SUBJECT: SFD2306-0122
SINGLE FAMILY DWELLING

Here are the results of all Inspections located at **489 S LINCOLN ST:**

Inspection Type: ROUGH IN
Scheduled Date/Time: 11/6/2023
Completed Date/Time: 11/6/2023
Inspector: Daniel L Floyd
Result: FAIL W/ PENALTY
Remarks: eTRAKiT Inspection Request
Notes: 11/2/2023 3:28 PM Pleasant Builders of NC LLC

FOUNDATION PLAN
STEM WALL

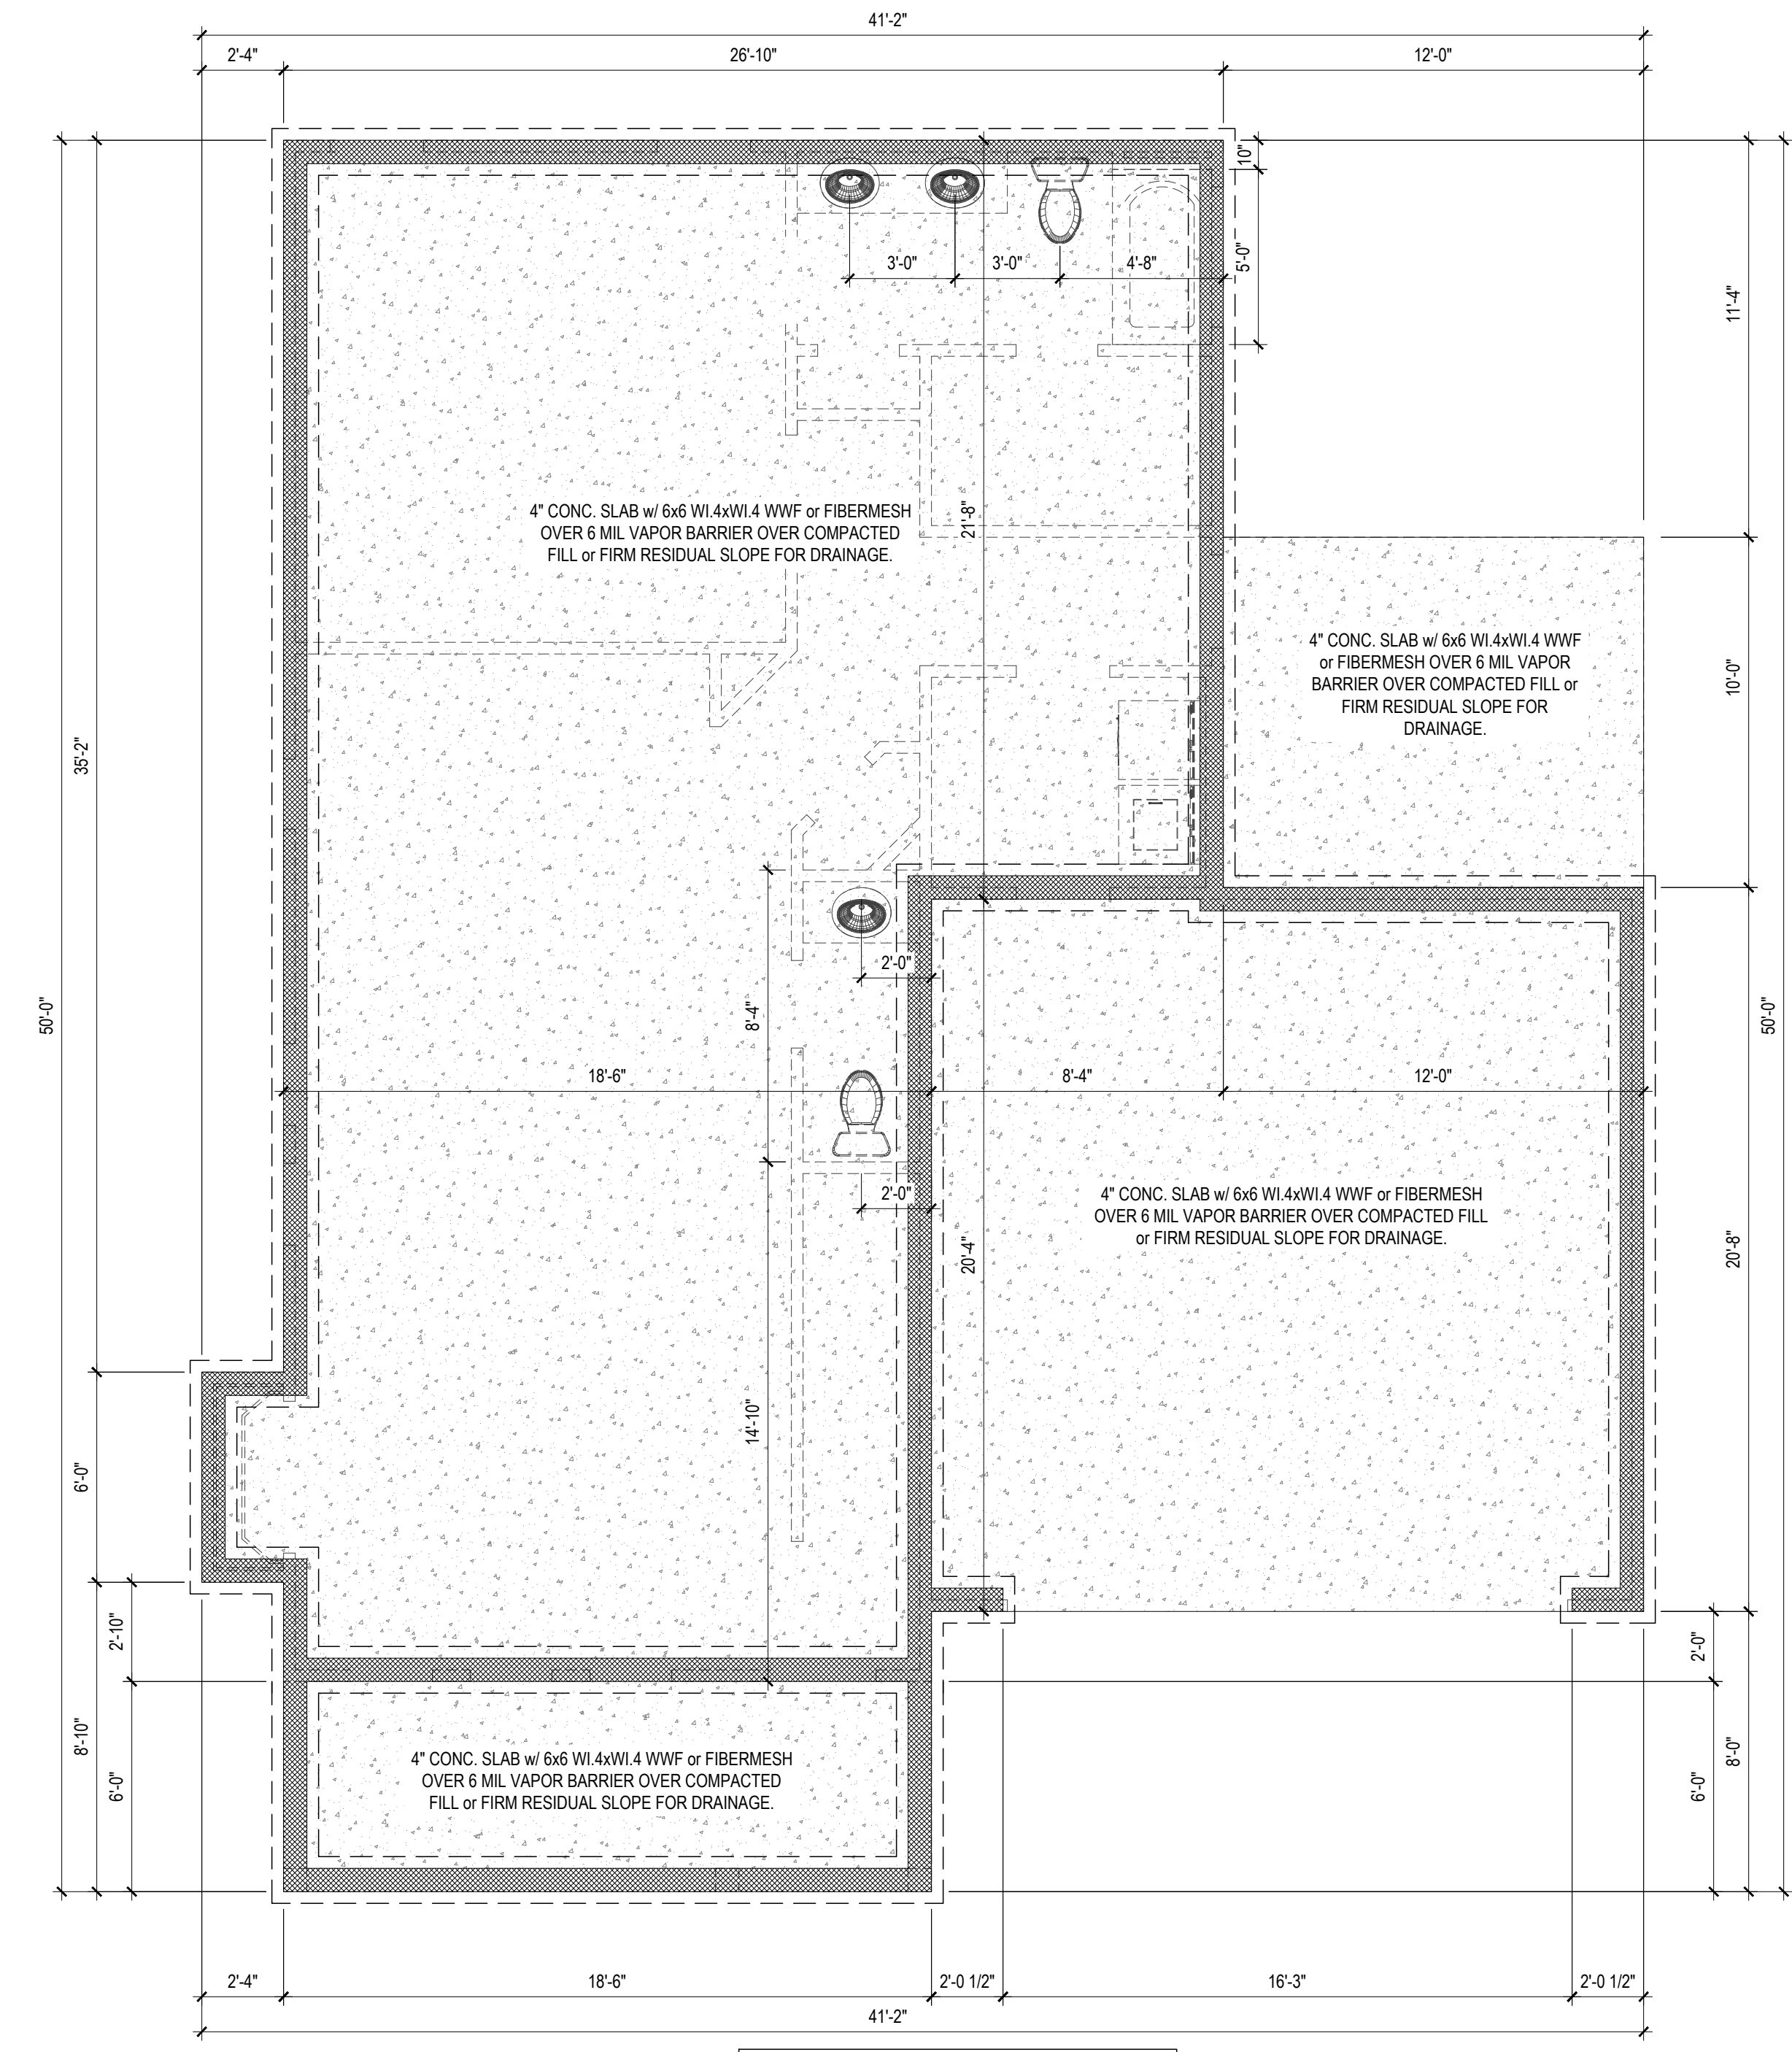
Need insulation on stem wall and need to be able to see projection on the inside of the garage wall.

FOUNDATION PLAN 1/4" = 1'-0" CRAWL SPACE

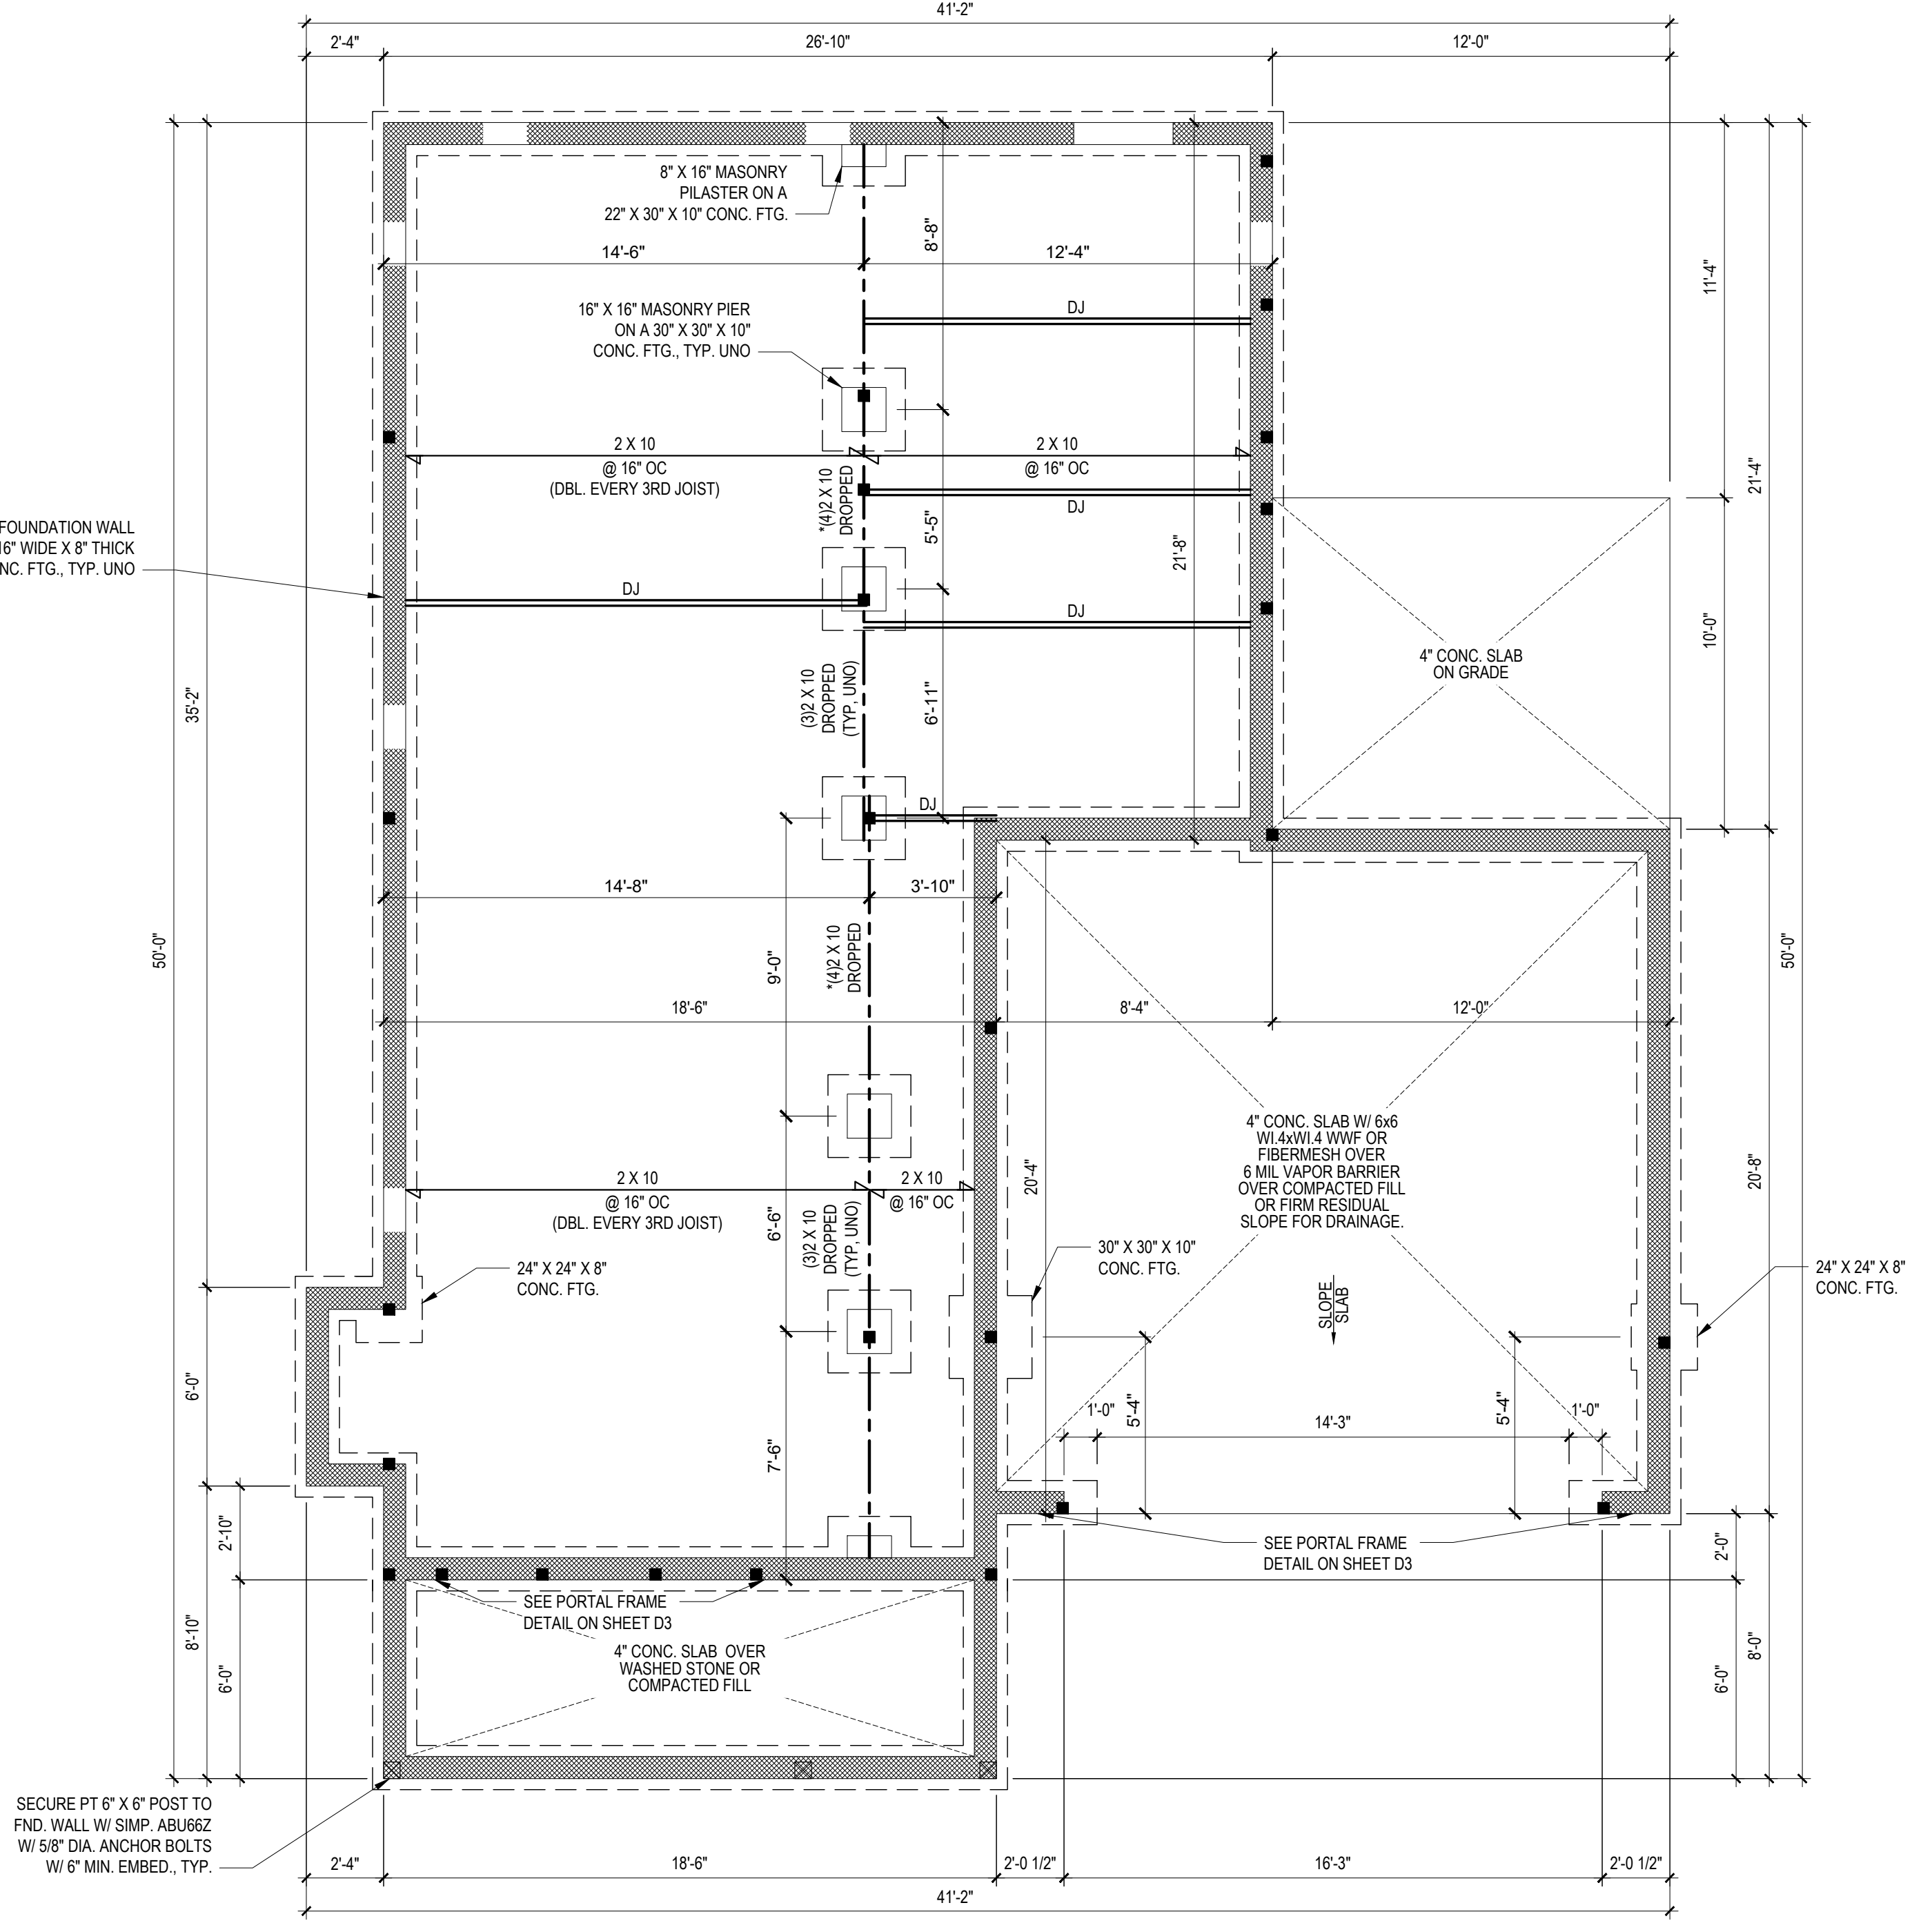
Inspection Type: 1. Need anchor bolts through out need 2 per member every 6ft and within 12" of the corners
Scheduled Date/Time: 2.Nail sheathing on the back of the garage 3. Repair foundation where it's been blown out in
Completed Date/Time: the garage 4. Need a letter for oversized lvls in the garage 5.Need to add a stud in master closet
Inspector: where studs are more the 24" oc 6. Anchor bolts in laundry room must be in the center 1/3 7.
Result: Need a nailer for the master shower 8. Need another king stud at master bedroom door 9.Need
Remarks: a chase built for ductwork running below the ceiling in closet with the water shutoff 10. Need
Notes: to add another stud on the stud column in the kitchen where stud is notched 11. Need a nail
plate where 3 inch drain in half bath is not completely in the wall 13. Need fire place installed

14. Anchor all interior load bearing walls 15. Fire alarms need to be 3ft away from all return 16.
Seal all holes in the air barrier 17. Drain test low No floor truss documents. do not insulate.
